Our ref: Blessed Carlo College, Moama (SSD-24262975)

Subject: Response to Submissions

The exhibition of the development application and environmental impact statement (EIS) for the Blessed Carlo College, Moama (SSD-24262975) ended on 07 Dec 2022.

The Department has also undertaken a preliminary assessment of the EIS and, in addition to the issues raised in agency submissions, requires the matters at **Attachment 1** be addressed in full.

1 SSSA_STAGE 1 WORKS
2 Scale 1 : 1000

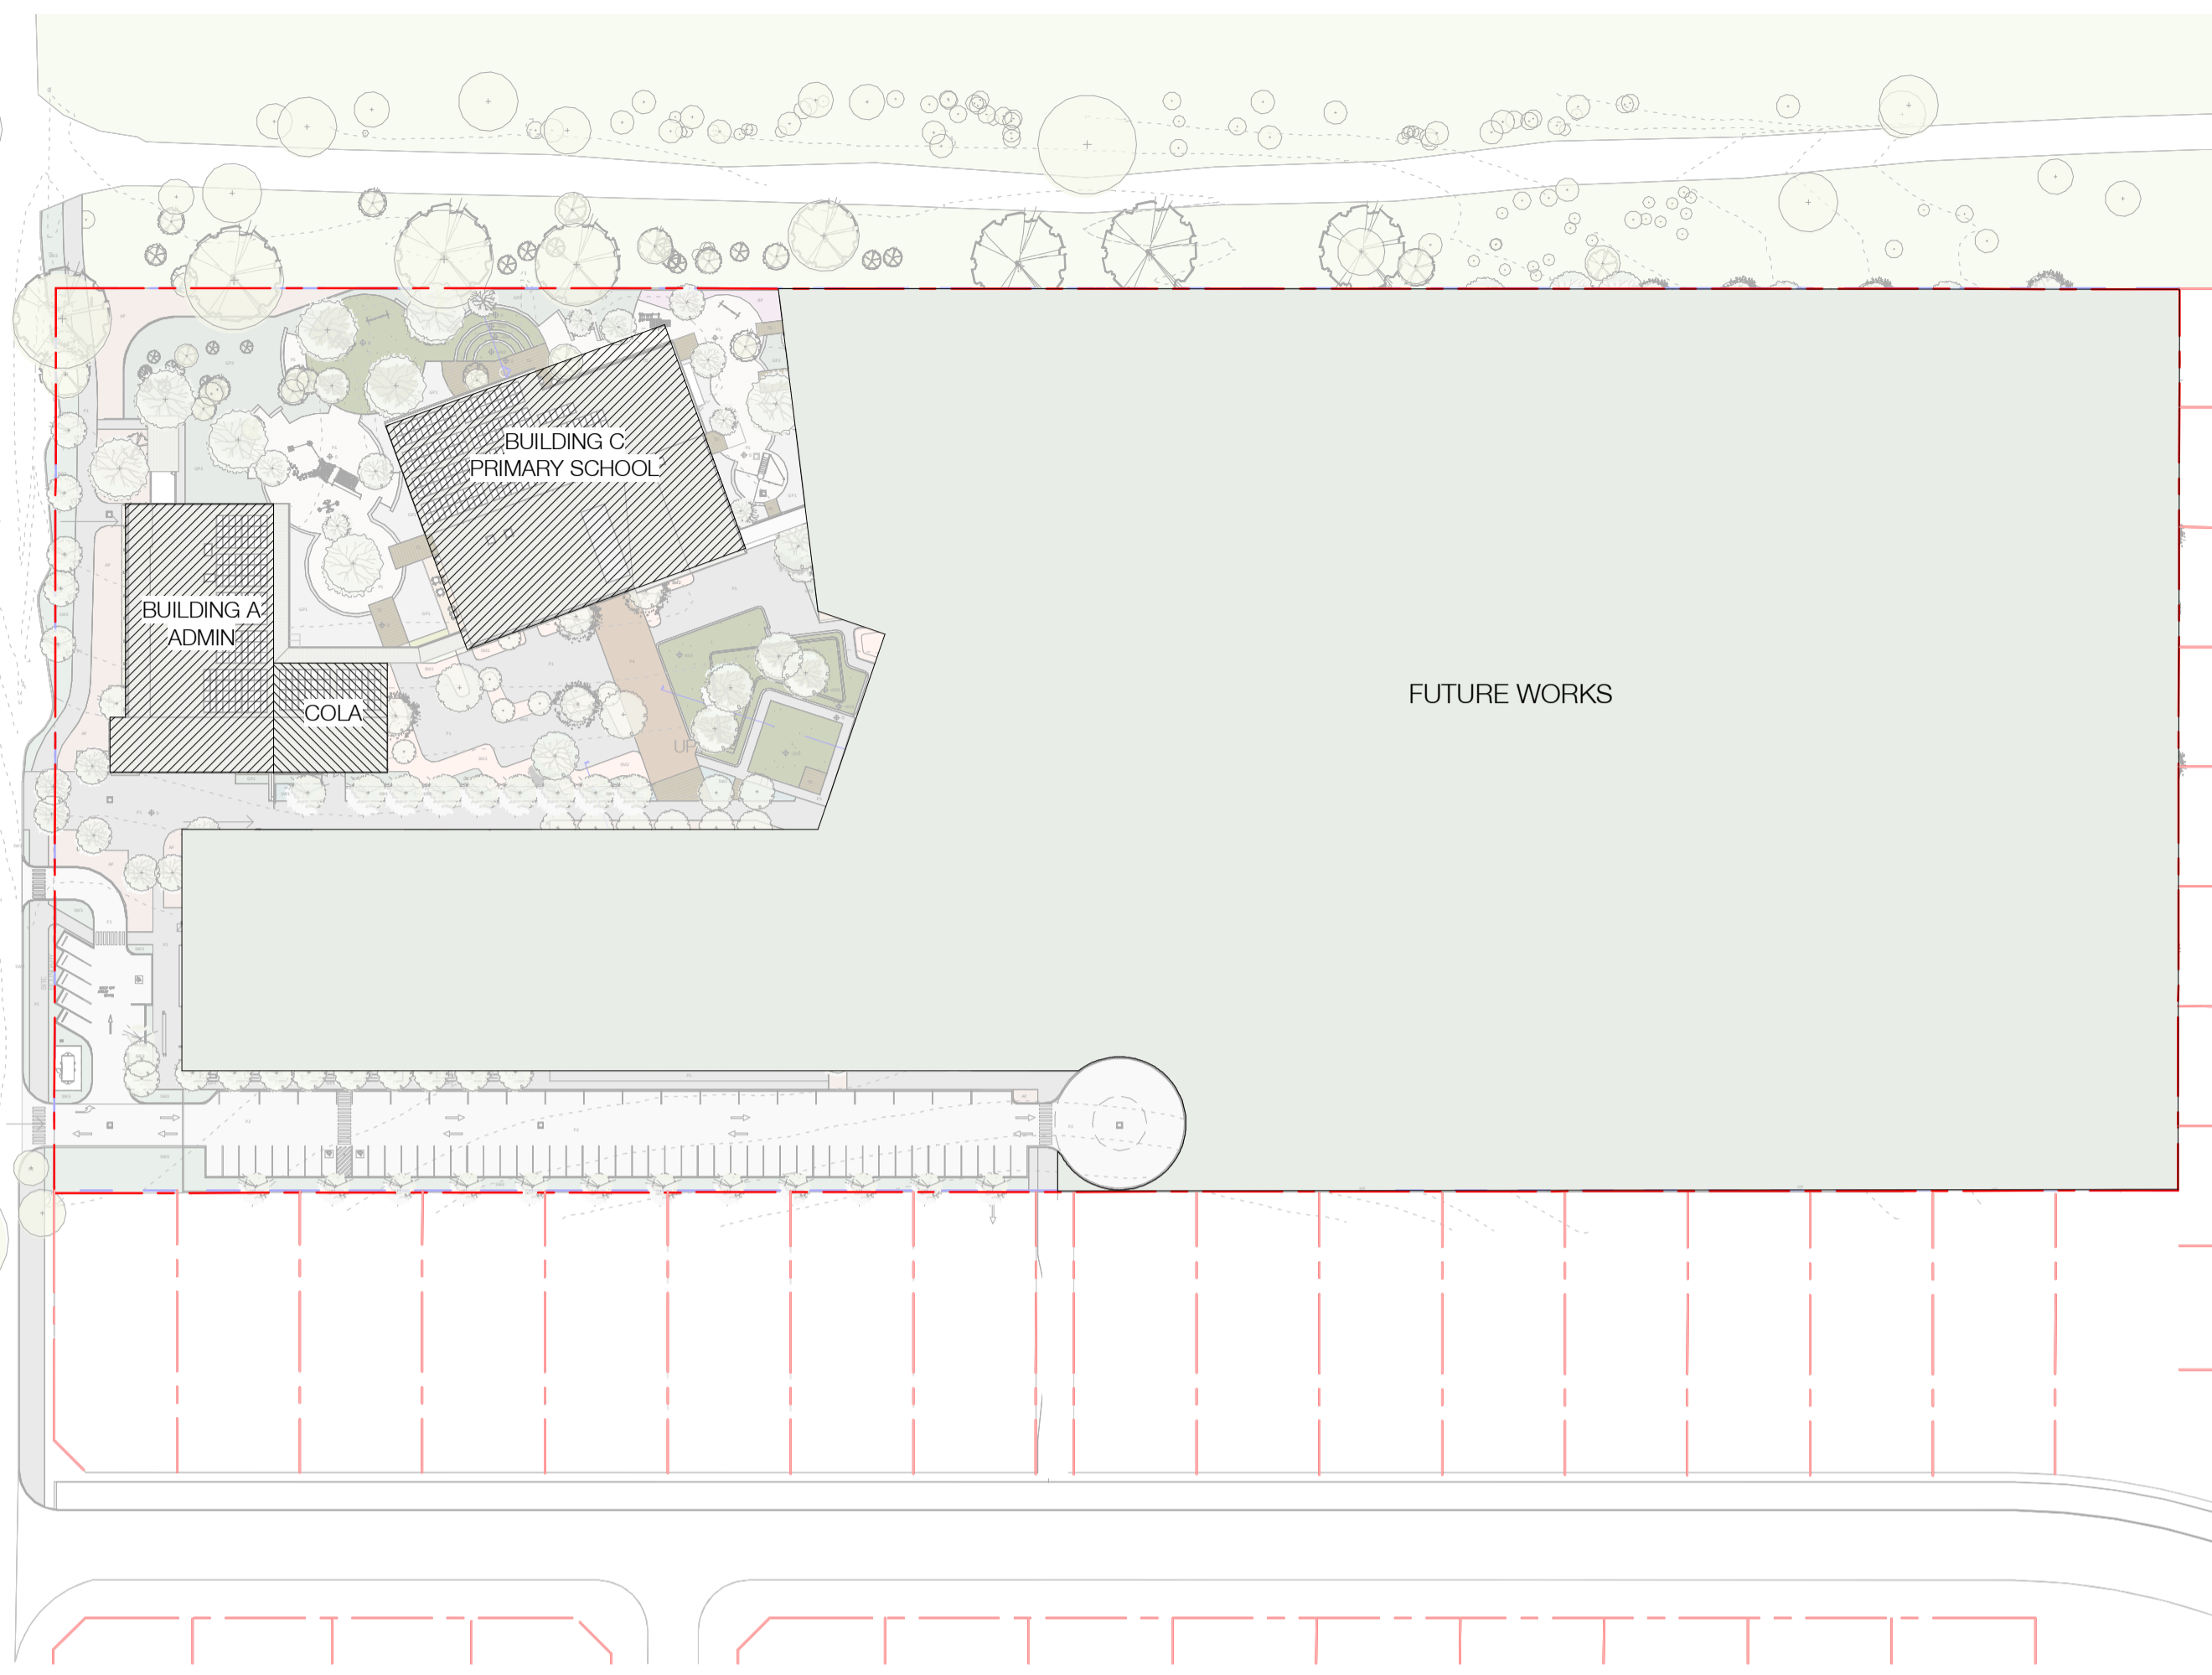
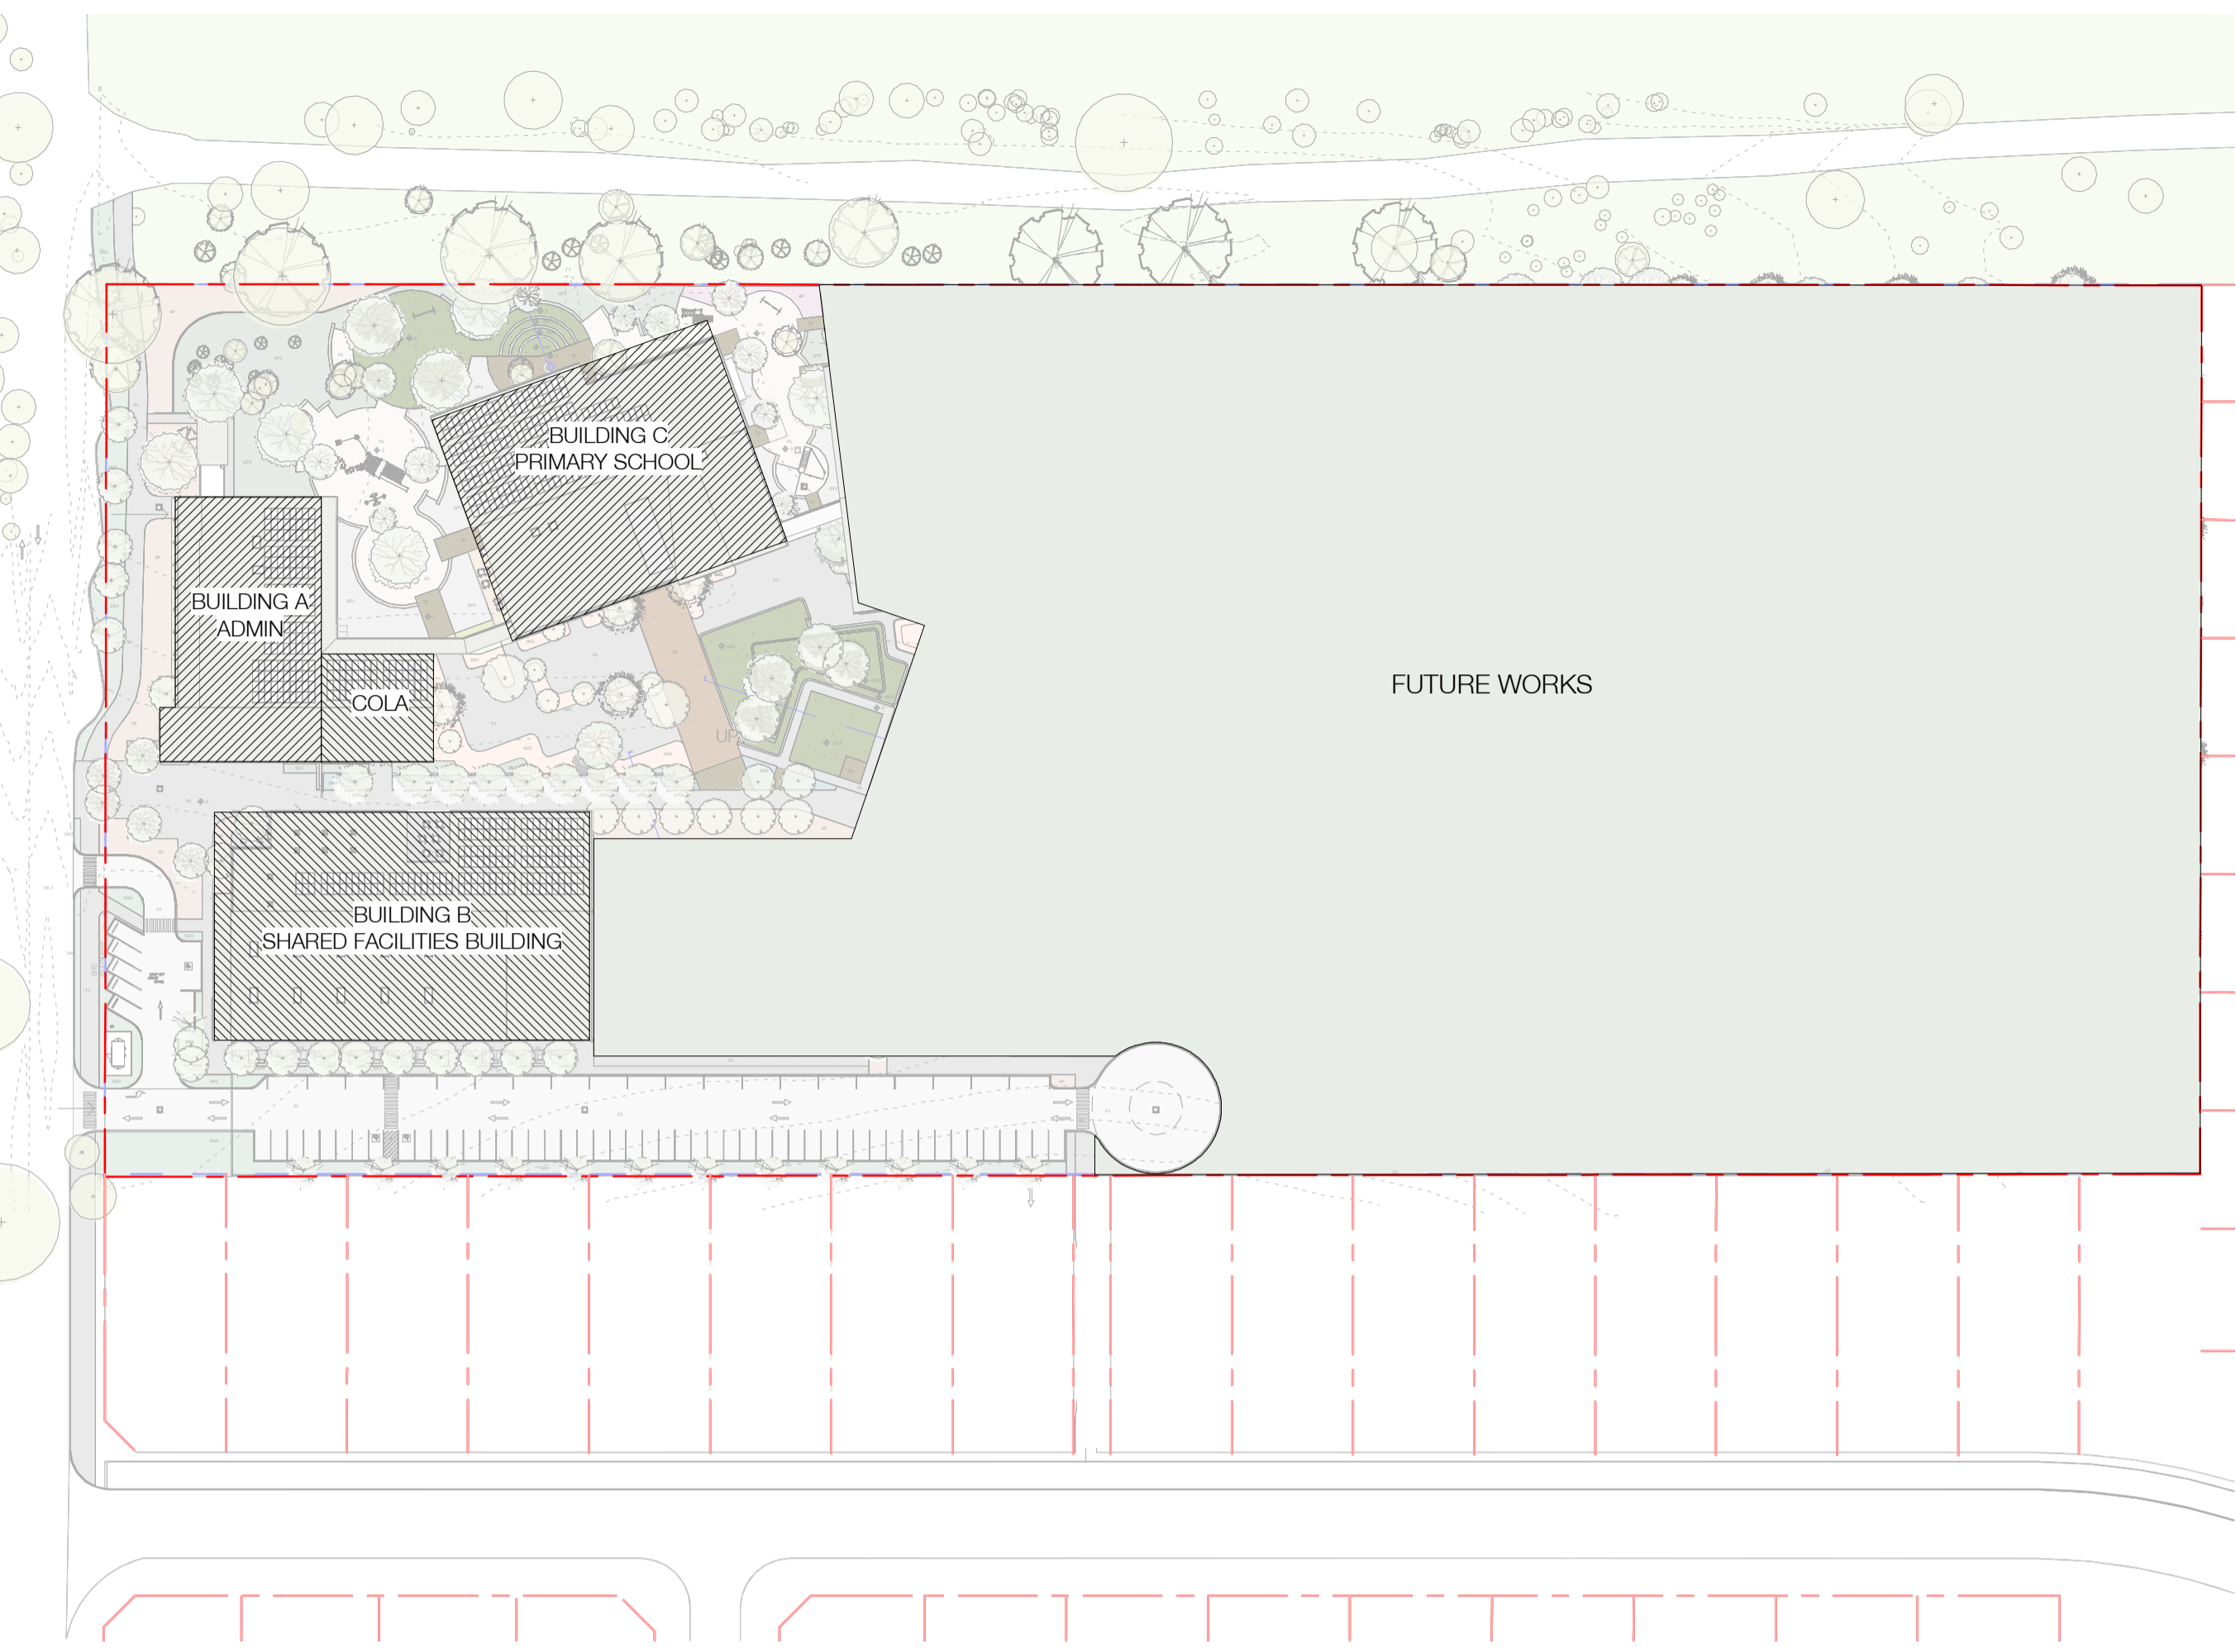
- The proposal would be delivered in four construction phases. In this regard the Department notes that the main open spaces and fields would be delivered in phase 4.
- Consequently, the Department requires you to provide details of the provision on open space and play spaces in each construction stage to demonstrate that at each operational phase the students have sufficient play space within the site complying with the 10sqm/student requirement of the Department of Education's Facilities Guidelines.
